## Engineers Comments Regarding Surface Water Drainage

<b>Application Reference:</b>	LU/96/25/PL	<b>Reviewer Reference:</b>	ADC/PC
<b>Planning Officer:</b>	Harry Chalk	<b>Date of Review:</b>	18/09/2025
<b>Site Name:</b>	16 Swanbourne Road Littlehampton BN17 6HS		
<b>Application Description:</b>	Erection of 1 No. single storey, self-build dwelling with car parking to include provision of driveway and car parking for No.16 Swanbourne Road. This application is in CIL Zone 4 and is CIL Liable as a new dwelling.		
<b>Assessment Number:</b>	1 of 1

- FOUL & SURFACE WATER DRAINAGE REPORT REV P1 (C3489)

JOB TITLE: 16 SWANBOURNE ROAD, LITTLEHAMPTON, BN17 6HS

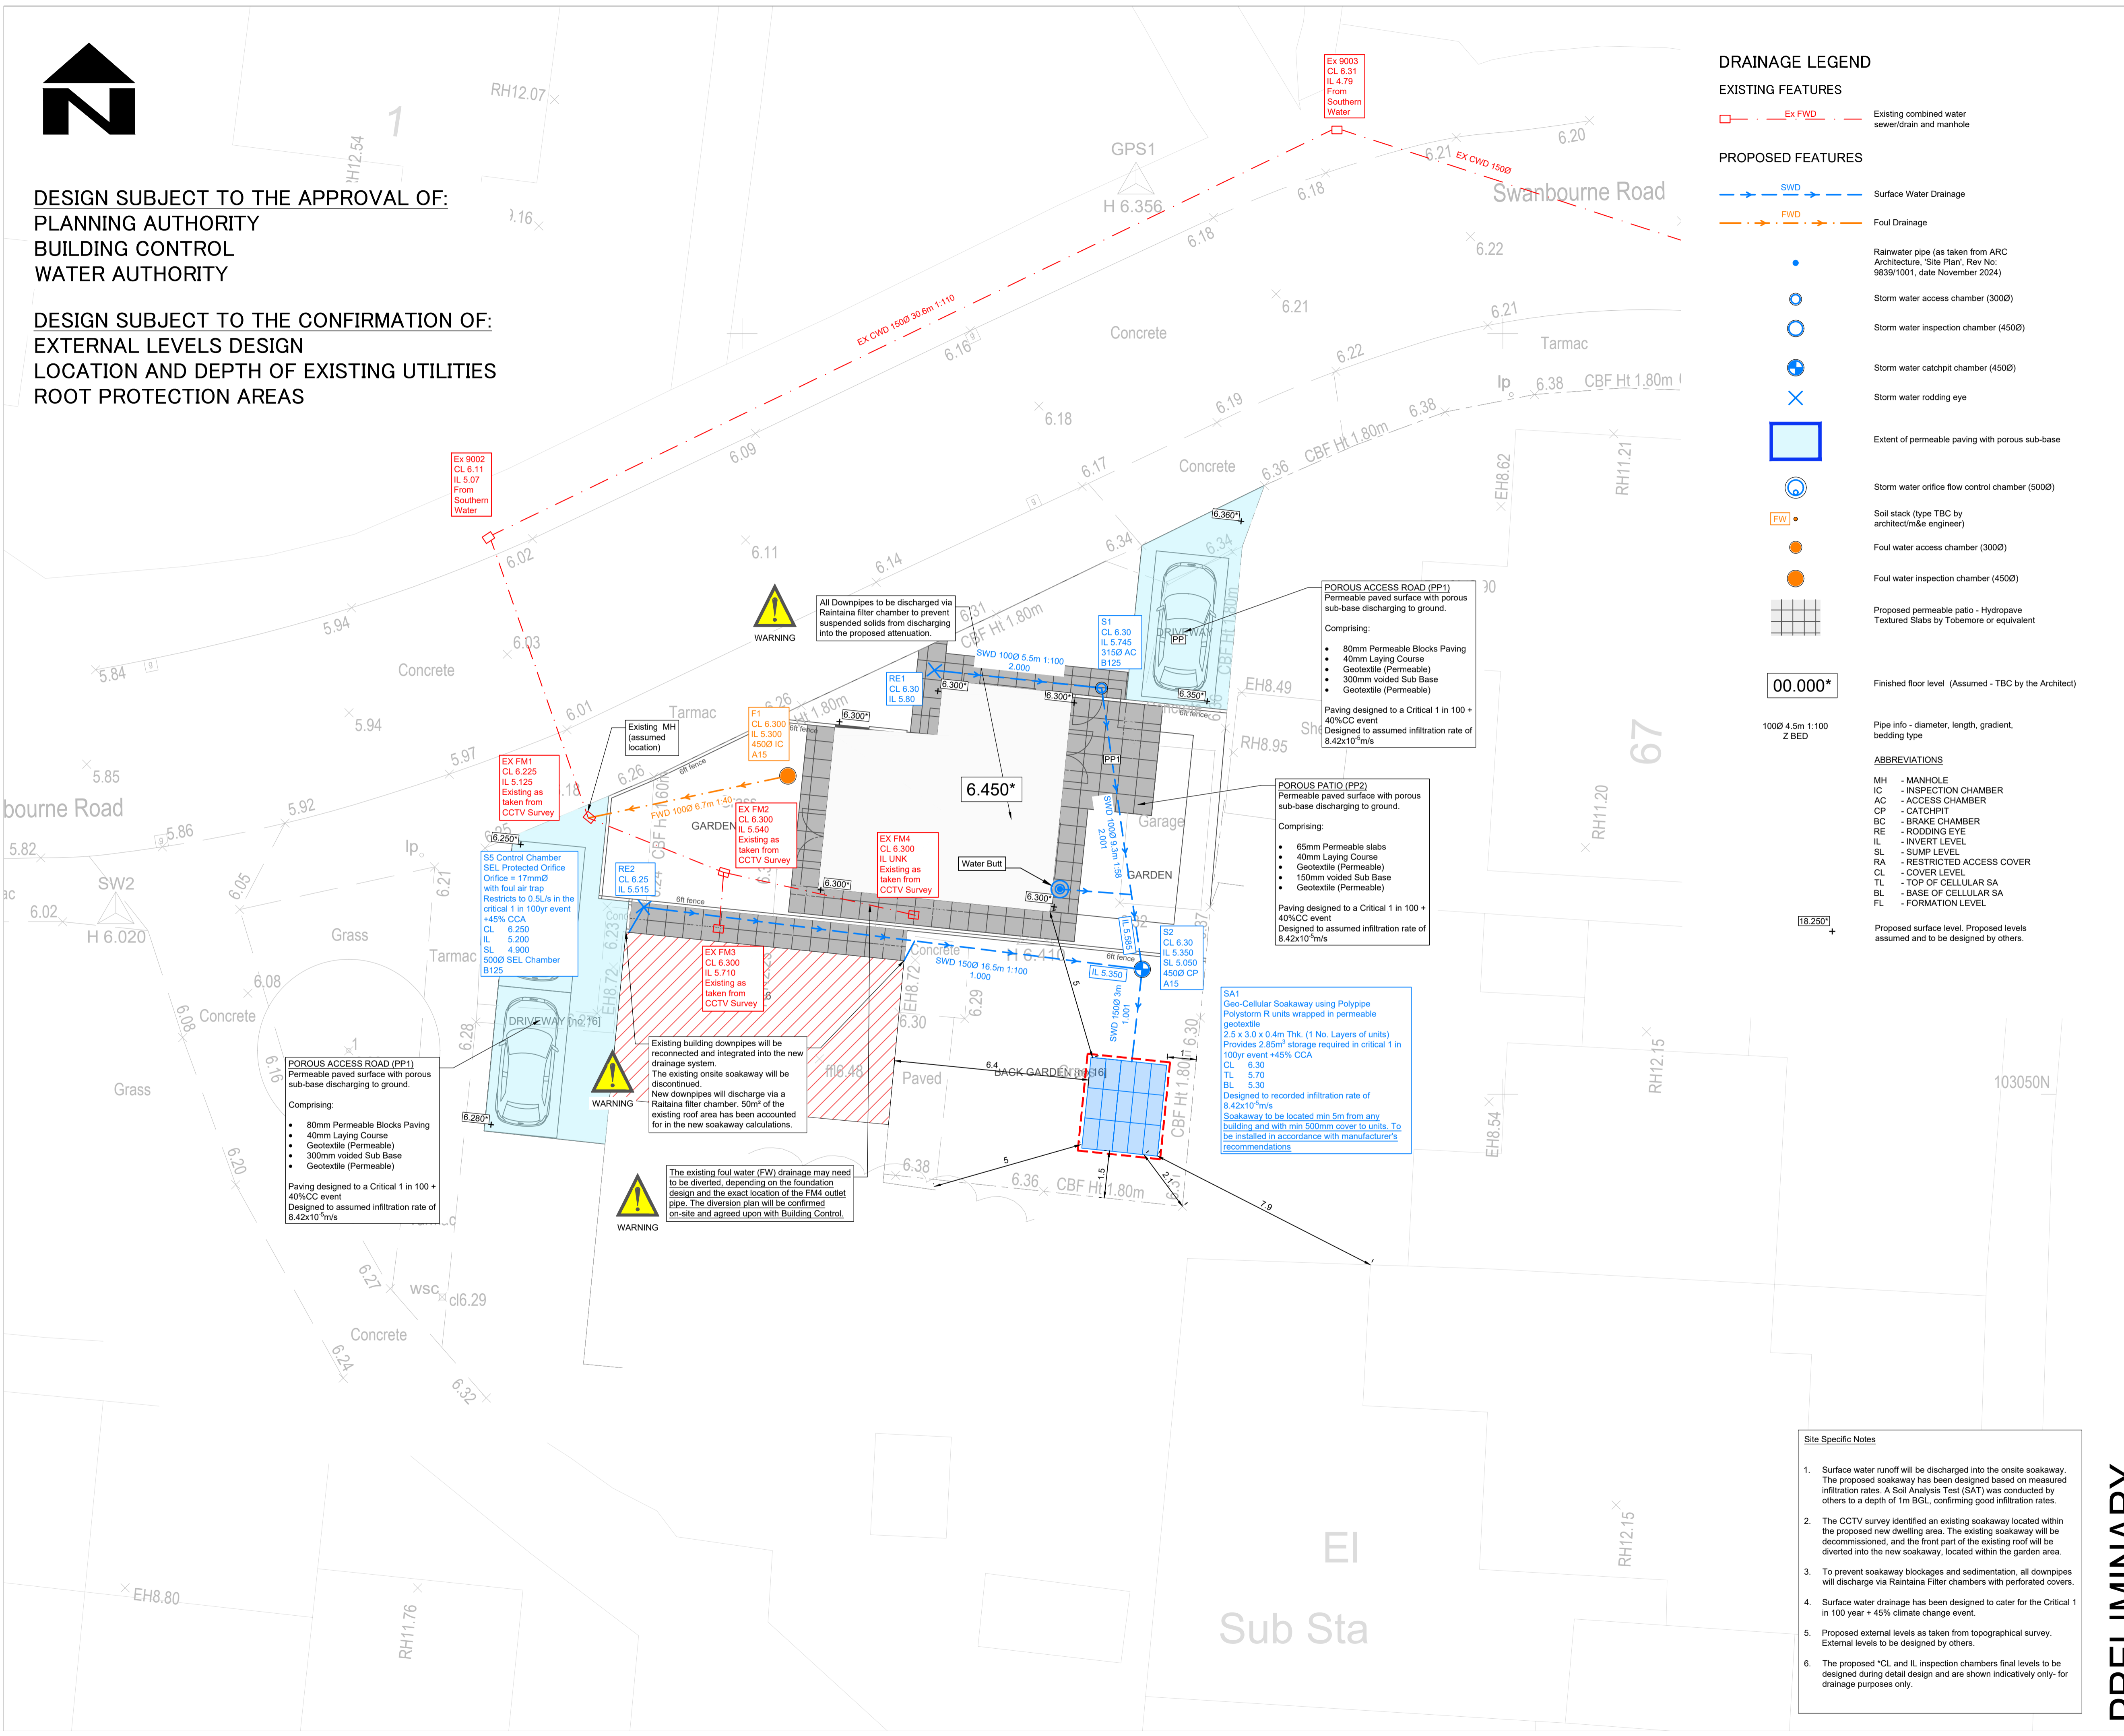
- iv. The 10% AEP (1 in 10 year) storm calculations do not include an appropriate climate change allowance.
- v. Calculations appear to show one of the permeable paving areas connecting to the main soakaway system but this is not reflected on the drainage layout plan.

- vi. Foul drain EX FM2 to EX FM3 may clash in terms of levels, with proposed pipeline RE2 to S2, when taking into account pipe thicknesses etc. Please review.

- vii. The drainage layout plan refers to an orifice control chamber but it is unclear how this is relevant to the proposed scheme.

- viii. Specify incoming pipe invert level at entry to soakaway. The invert needs to be set above the peak water level predicted for the 1 in 10 year storm (+ climate change allowance).
- ix. Dimension impermeable areas on contributing area plan.
- x. The infiltration rate has been applied to both the sides and the base of the soakaway
- xi. The drainage layout plan indicates that the storage for the permeable paving areas is designed upon a 1% AEP (1 in 100 year) storm + 40% climate change allowance. This should read 45%.

The new dwelling is missing a RWP (should connect to pipeline RE1 to S1).

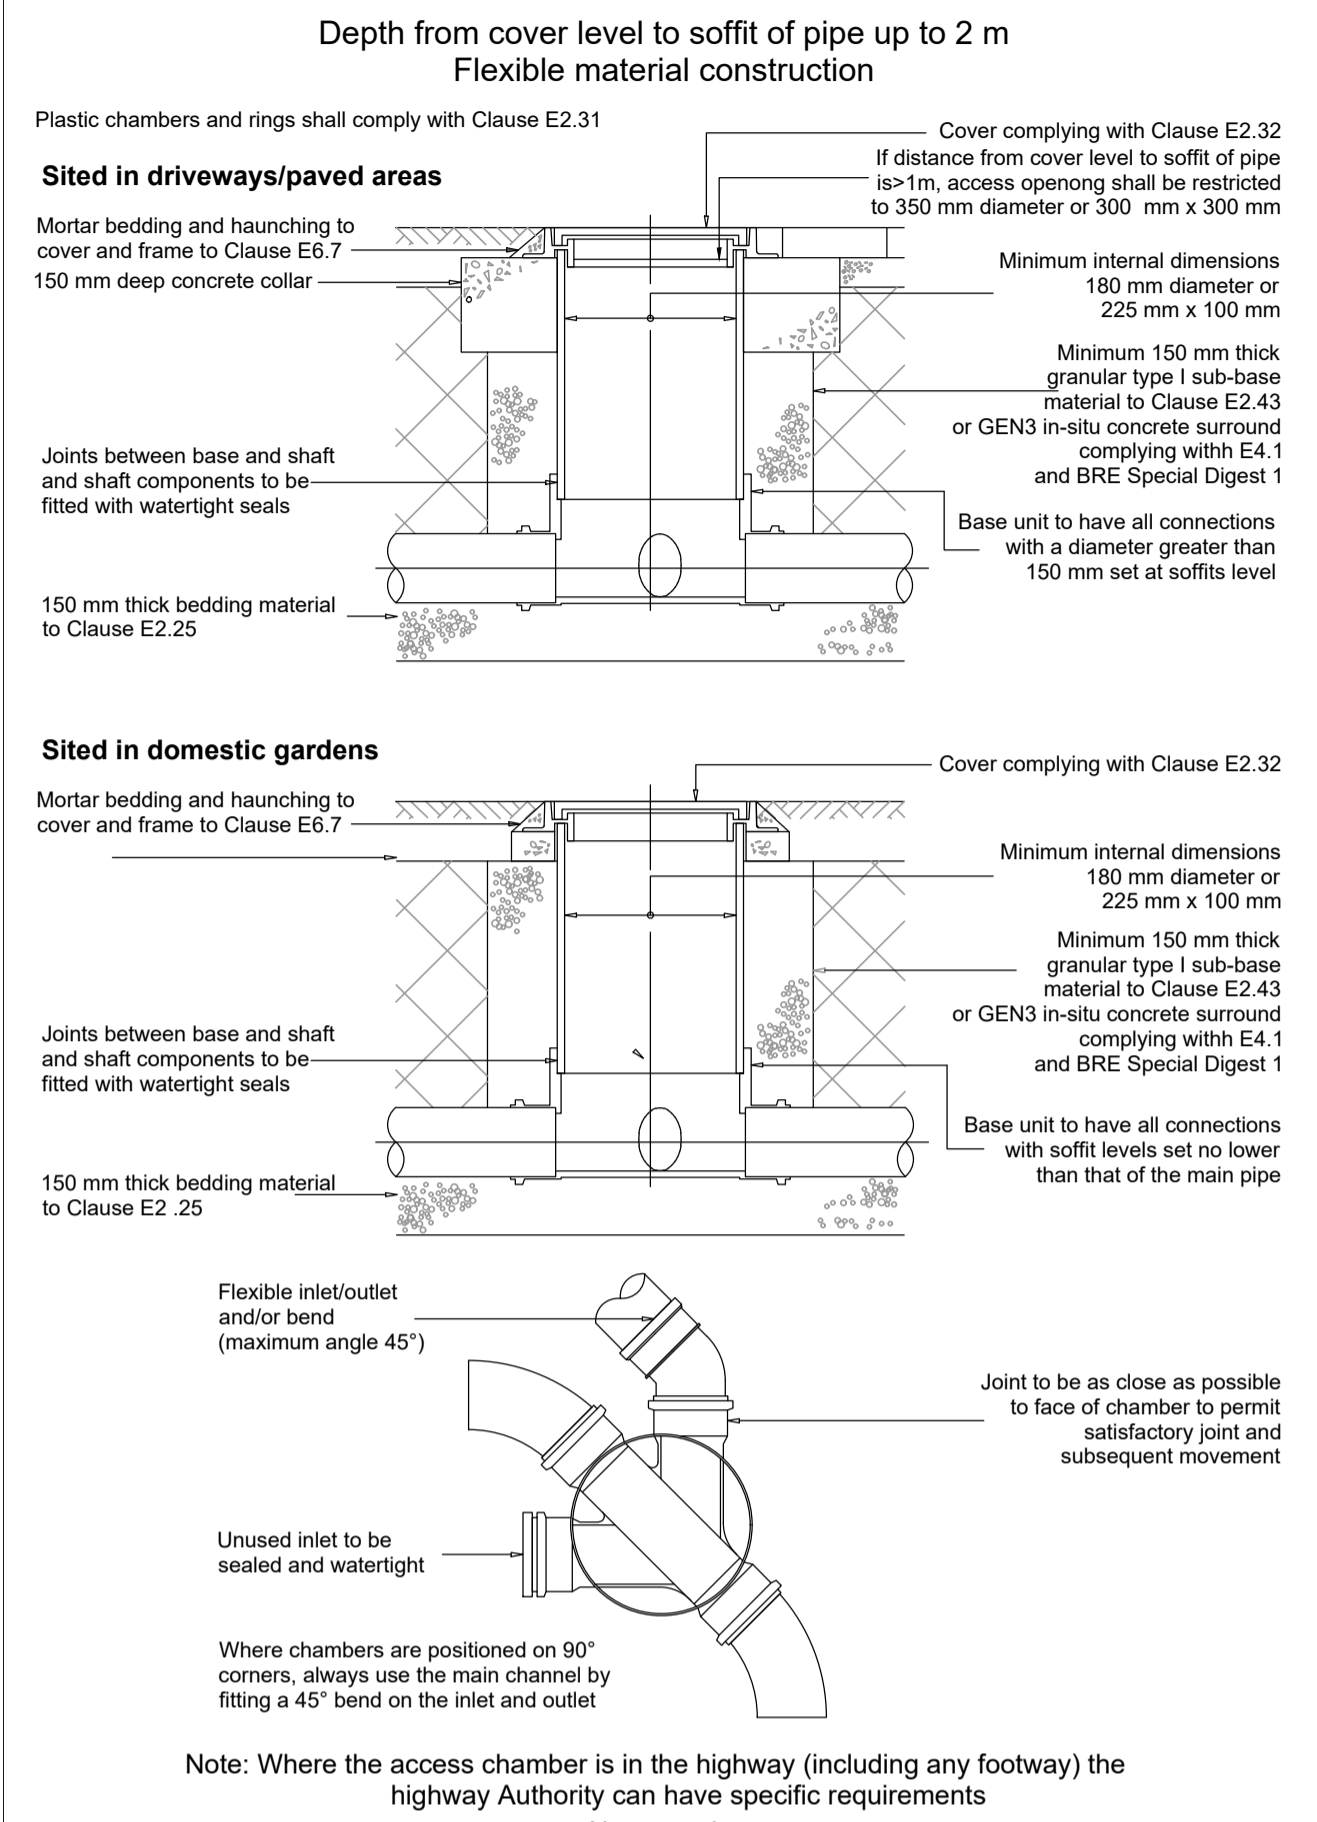
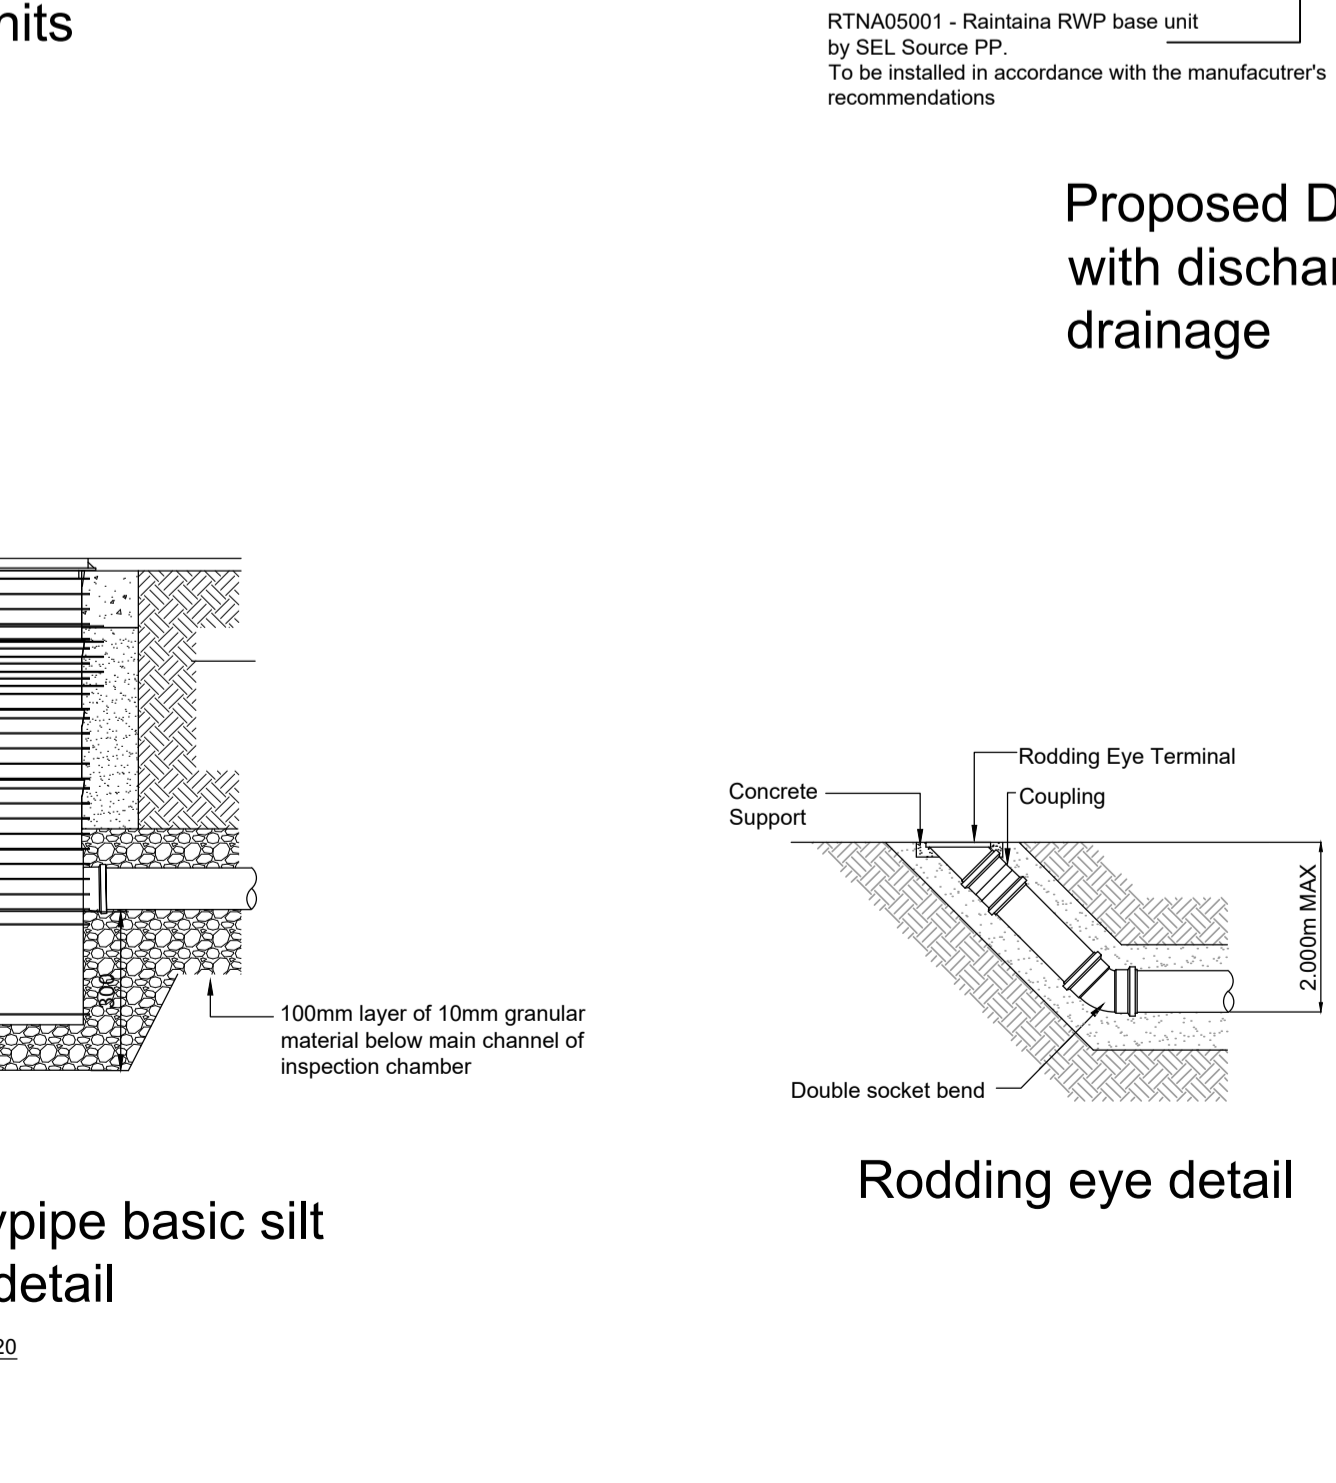
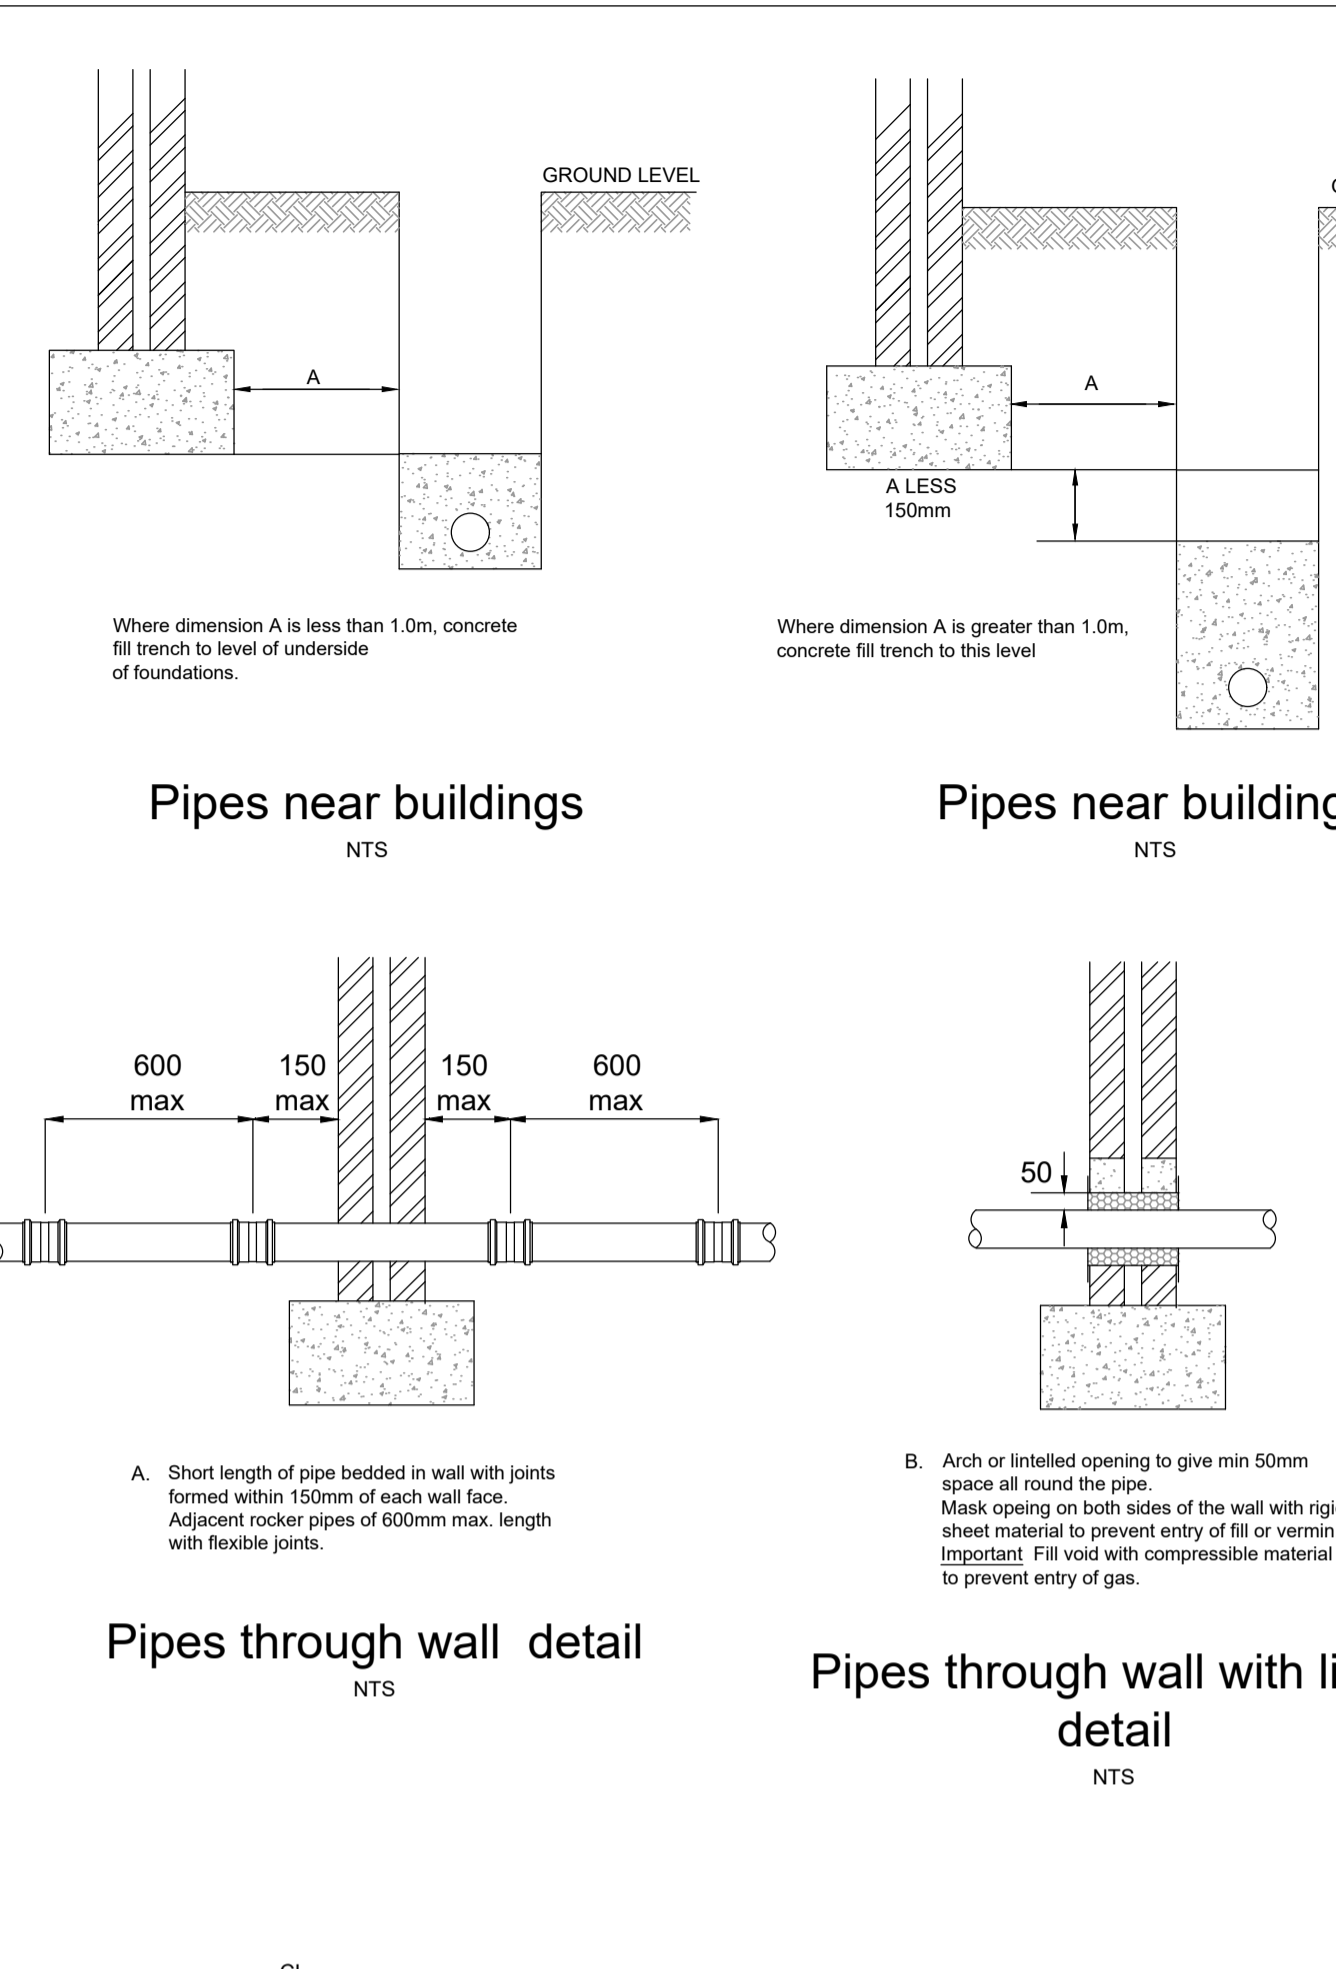
We suggest that the silt trap construction detail is adjusted so that the 300mm dimension is from the pipe invert to sump base.
